**Consultation Response from KC,
Conservation and Design**

2022/90875 Fieldhead, 1, Lidget Street, Lindley, Huddersfield, HD3 3JB

Variation of condition 1 (plans and specifications) on previous permission 2018/90082 for variation condition 2 (plans) on previous permission 2016/93798 for Listed Building Consent for conversion and extension of existing building, including part demolition, to form wedding venue and restaurant with bedrooms, and ancillary car park together with community use

Date Responded: 05.05.2022

Elevation B

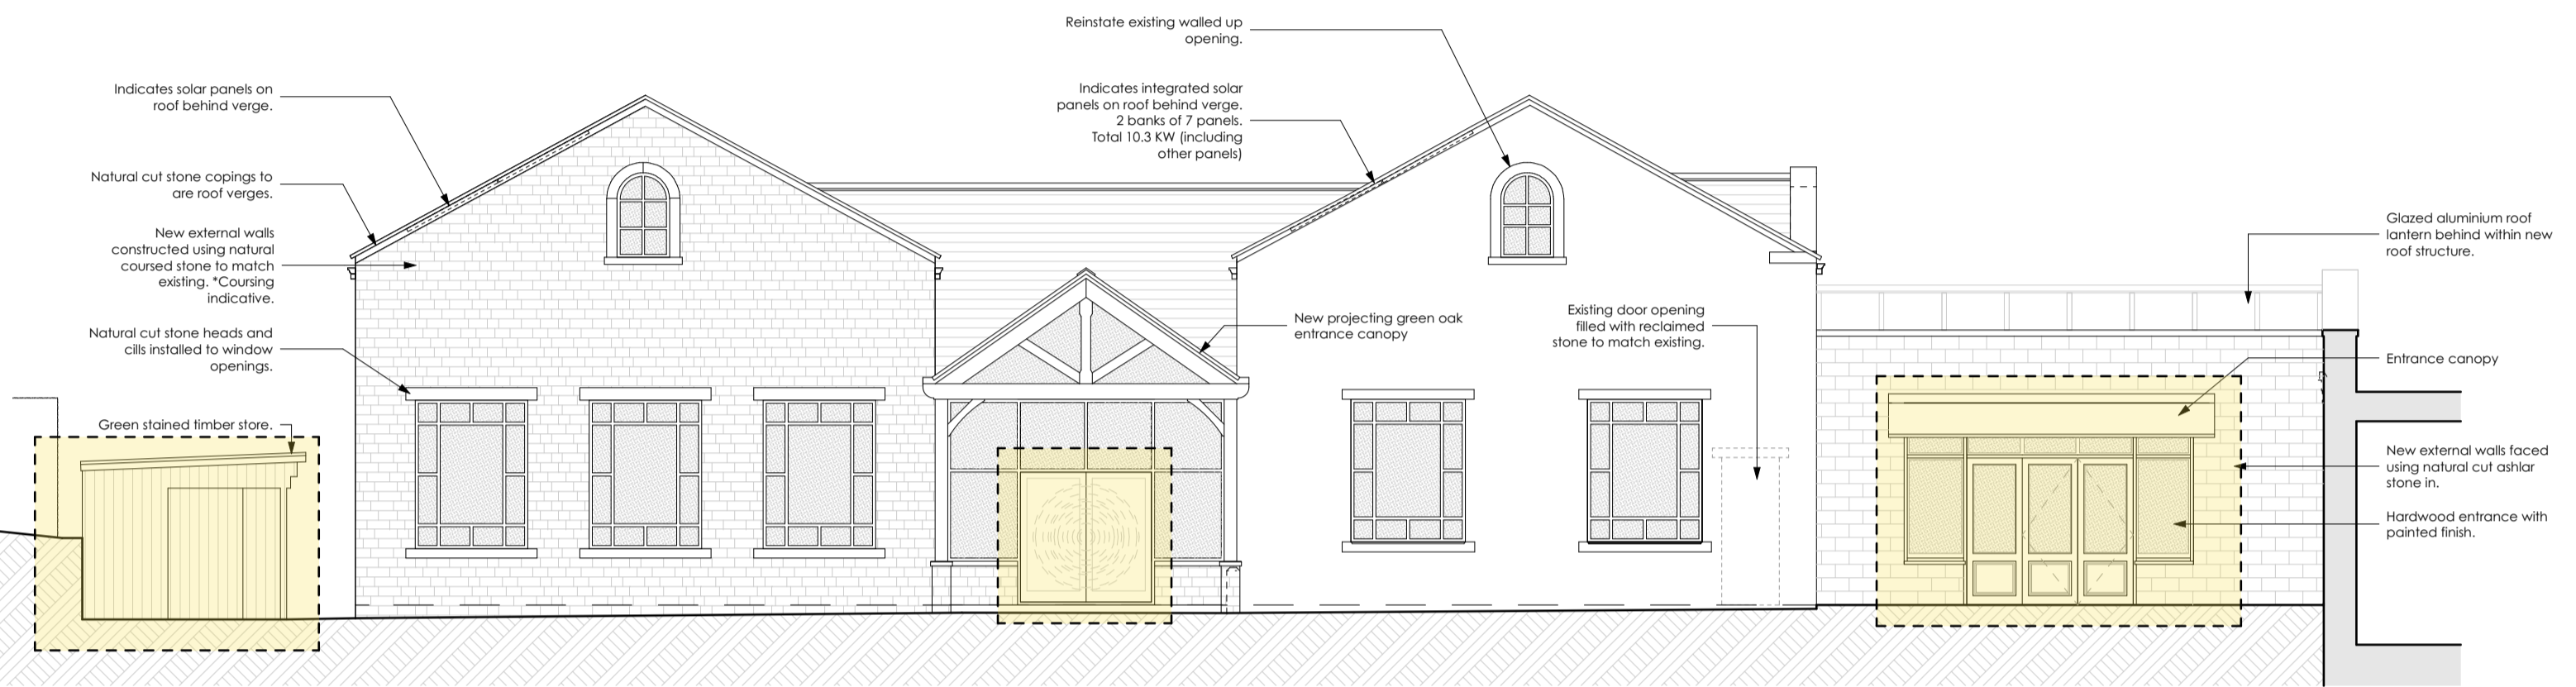
The drawing shows a proposed increase the height of the close boarded fencing. The increase is not noted as a change, however comparing to the previous approved plans there is a notable increase. We would raise concerns in this respect as this will make the new fencing more visually obvious. The fence should be reduced to the previously approved height.

The drawings again show the increase in height of the timber close boarded fencing. I would echo my previous comments in respects of the height of the fence.

The drawings show changes to the set of double doors which are now to be largely glazed double doors. The previously approved vertically boarded doors were of a more appropriate style, we consider the doors should be amended to the previously approved design. Further along the elevation the main larger opening has been amended to what appears to be a glazed seamless style, with a central logo. We are not convinced by this amendment. We are of the view the previously approved door style should be reinstated and the logo removed.

Elevation D

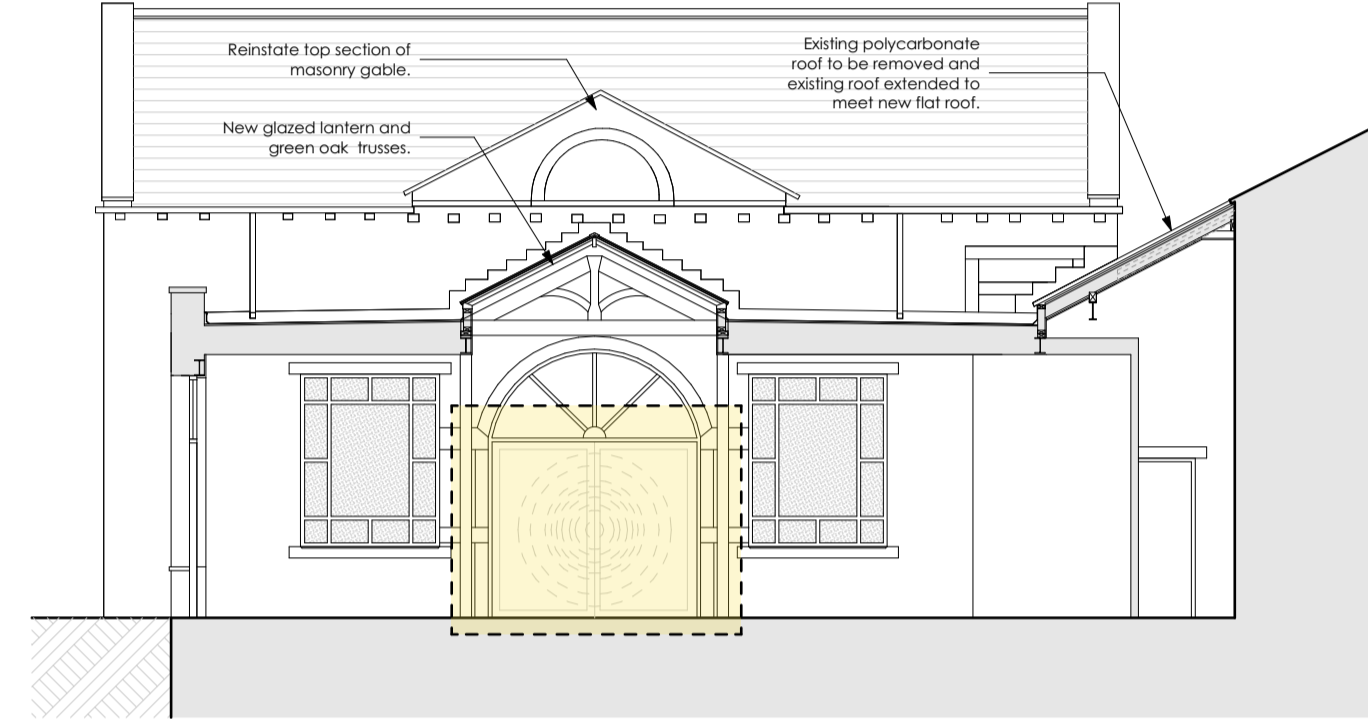
To the left of the elevation there is a proposed detached timber store. The store is of a considerable size and proposed to be set near enough in line with the main elevation. We consider that the store should be reduced in size and set back from the main elevation.

The main front door had been amended. The doors appear to be more seamless and again has the addition of a logo. As per previous comments we consider the logo should be removed.

Further to the right of the elevation the large opening has been amended to a simple set of casement windows and doors with a projecting canopy. The former approved detail showed a more decorative style of window with curved window heads. Conservation considers the submitted detail does not enhance the character of the building and would request that the previous approved detail from 2018 is reinstated.

Sectional Elevation E

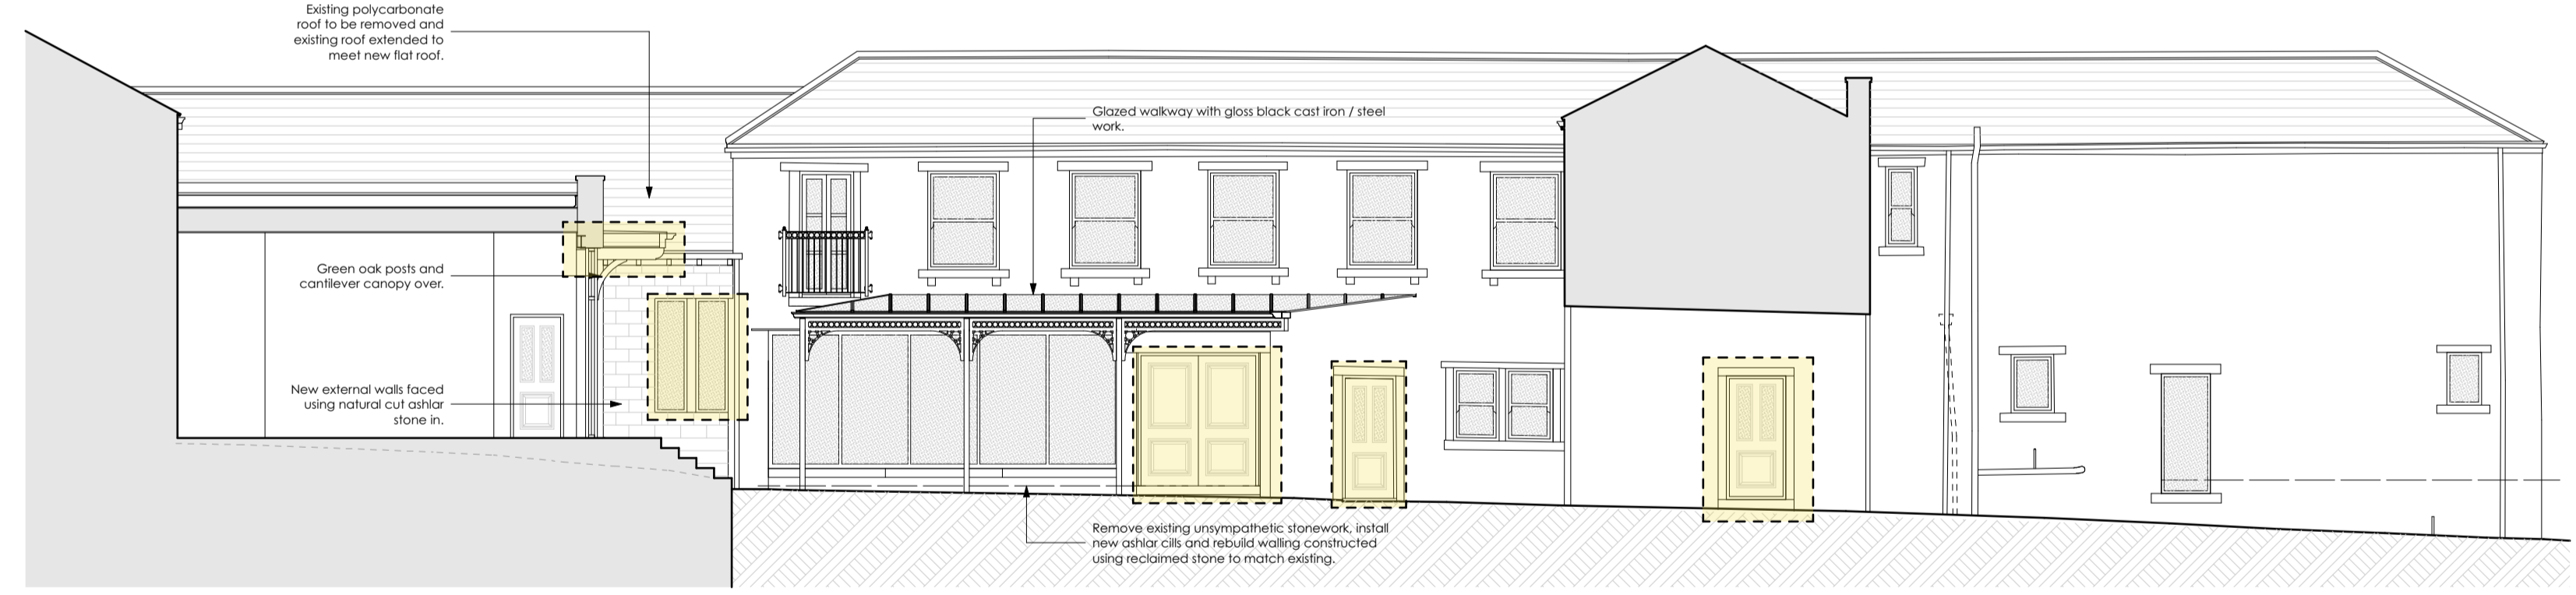
The plans proposed the arched opening to have a glazed infill with a top curved head transom. Conservation would ask for the Logo to be removed, but consider the principal to be acceptable, however there is currently insufficient detail for the proposed infill.

Sectional Elevation F

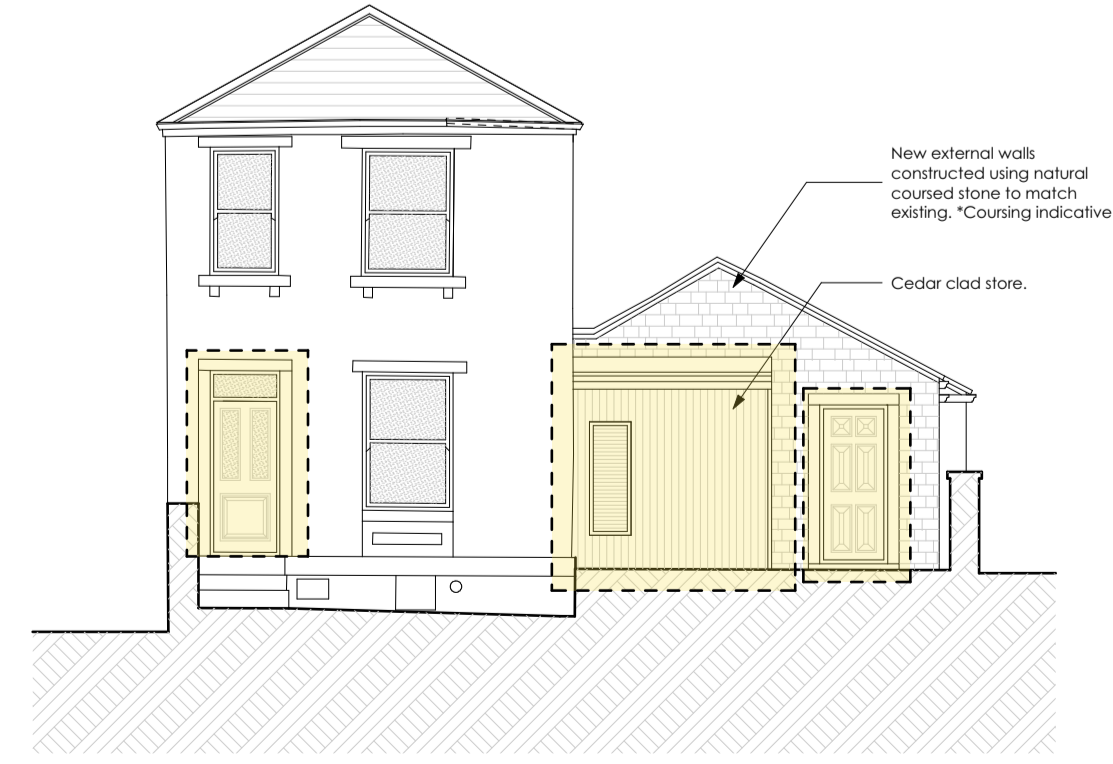
To the left-hand side of the elevation it shows that an existing sash window is to be altered and casements fitted. Conservation objections to this amendment and the existing sash should be retained.

Along the elevation a series of doors are shown as being amended, instating what appear to be simple panel doors. There is insufficient detail for the proposed doors. The previously approved doors were vertical panel doors. Without sufficient joinery details for the doors full comments can not be provided.

Elevation G

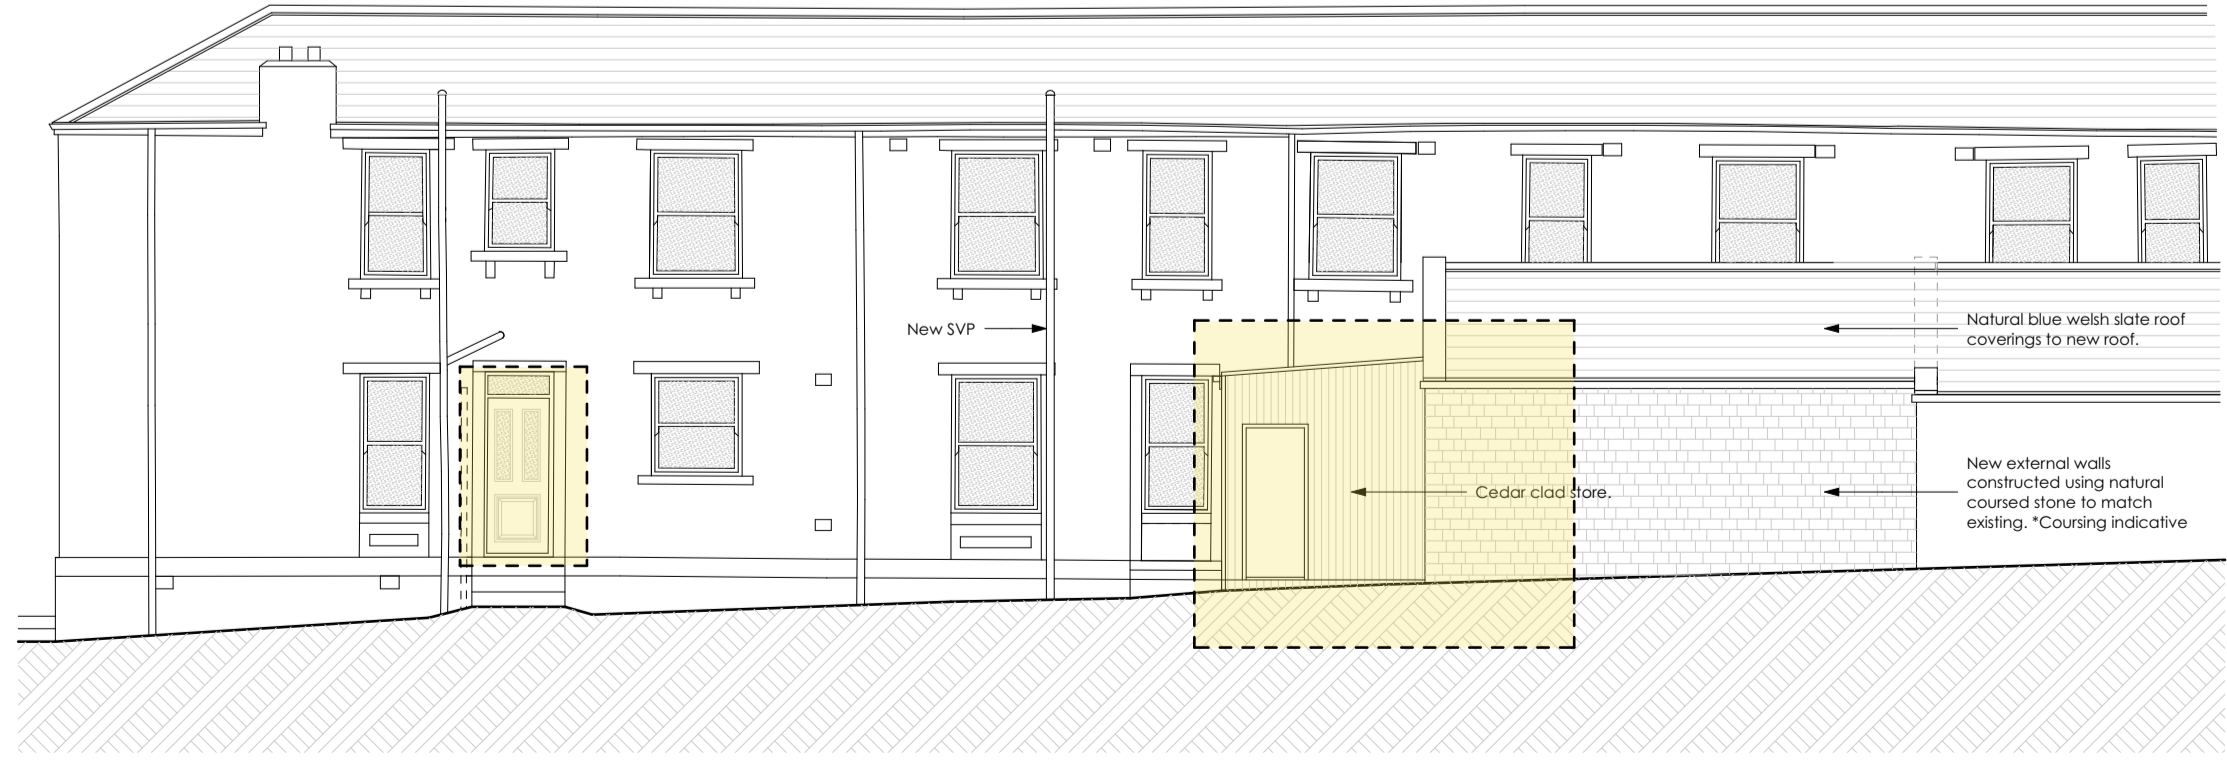
The elevation shown the proposed new attached timber clad store. Conservation would ask that the store is detached from the existing structure.

There are again further amendments to proposed doors. As previously stated there is currently insufficient detail. Full joinery details should be submitted.

I would echo my comments for elevation G.

<b>Client:</b> Bankgate
<b>Project:</b> Fieldhead, Lidget Street, Lindley.
<b>Drawing:</b> Elevations - Sheet 2 - Listed Building Consent

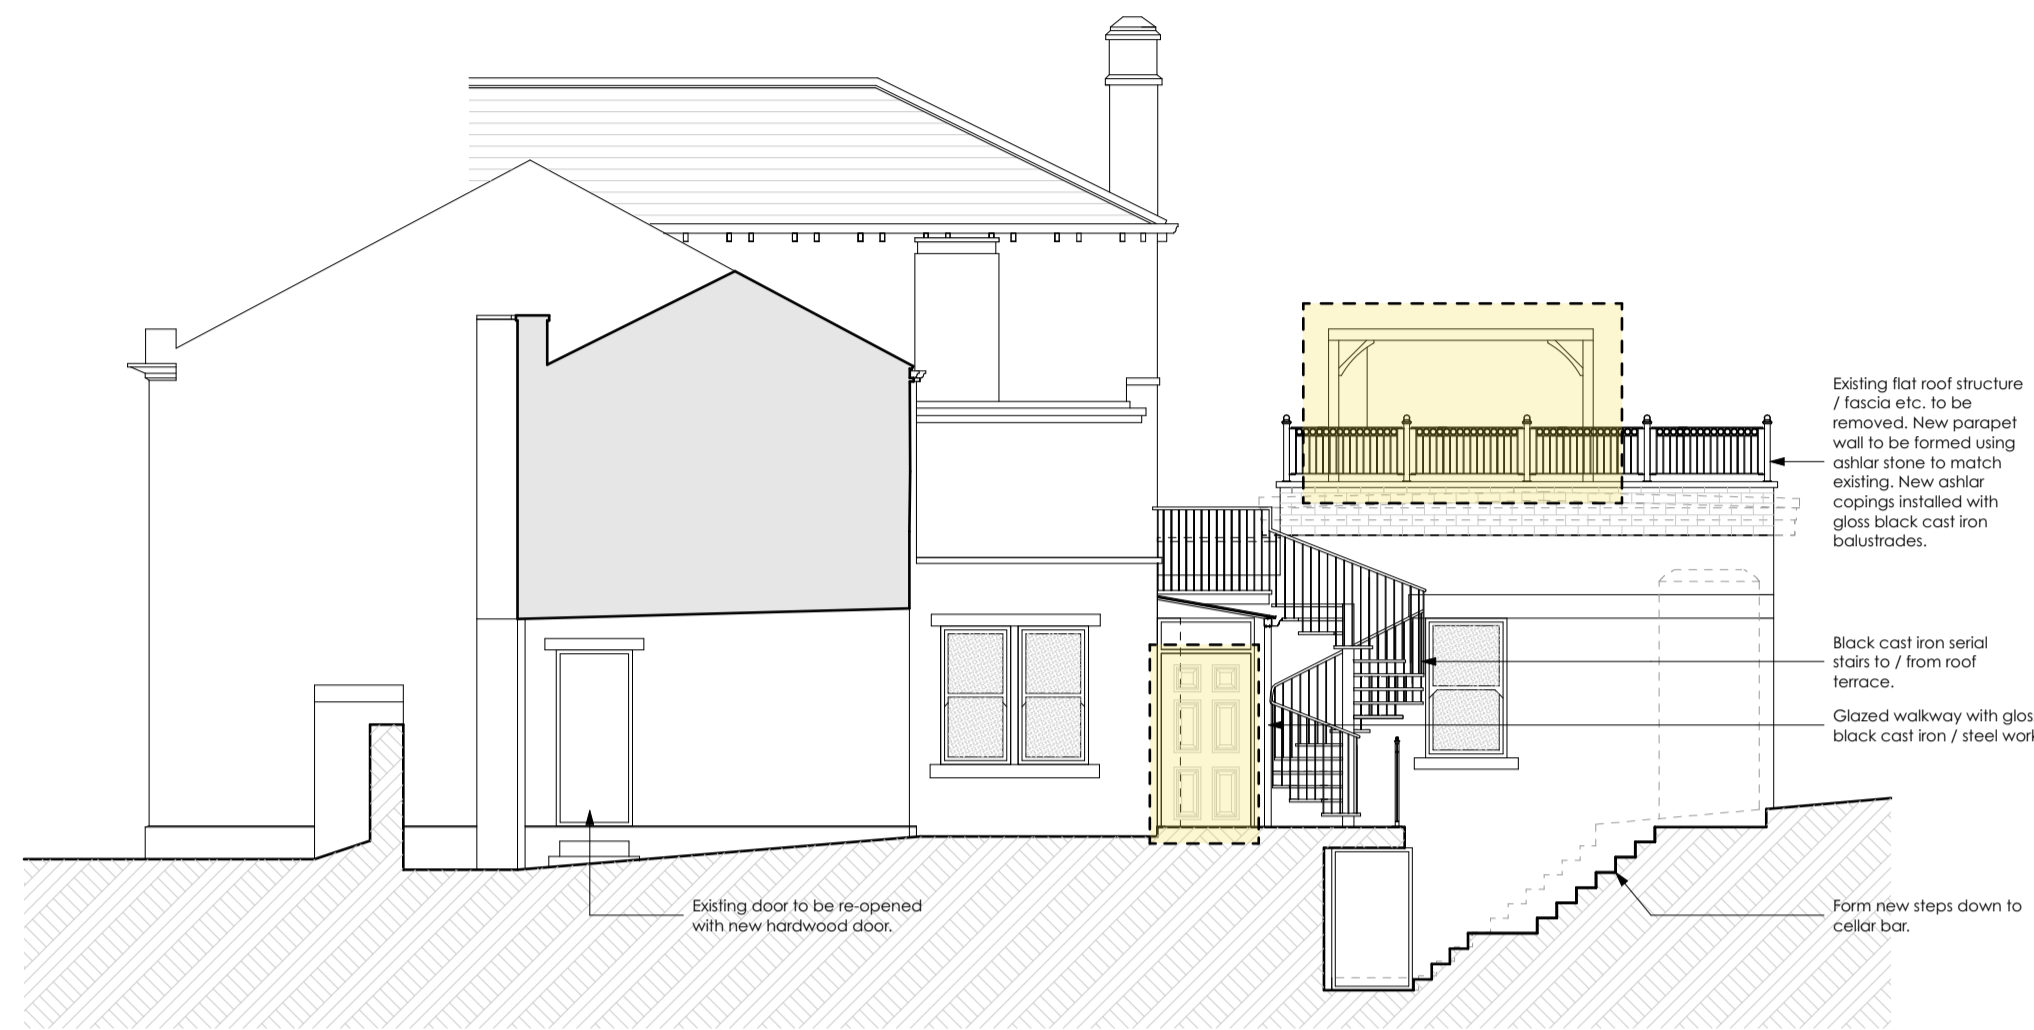
There are further door styles proposed, again with insufficient joinery details. To the flat roof section a projecting pergola is proposed. Conservation do not consider this to be appropriate. The feature appears and alien feature, which does not enhance the character of the property. We consider this should be omitted from the revised plans.

An existing sash window is shown as being amended to a set of double opening doors with balconette. Conservation do not support this amendment as this would see the alteration of a historic opening where there is no precedent for such alteration. We do not support this element of the revised plans.

Please refer to previous comments on the proposed pergola. Again there is insufficient joinery detail for the proposed doors.

Conservation consider the proposed design for the larger set of doors to the right hand side of the elevation to be entirely inappropriate. The previously approved detail was more appropriate and should be retained. We object to the design of the proposed larger doors.
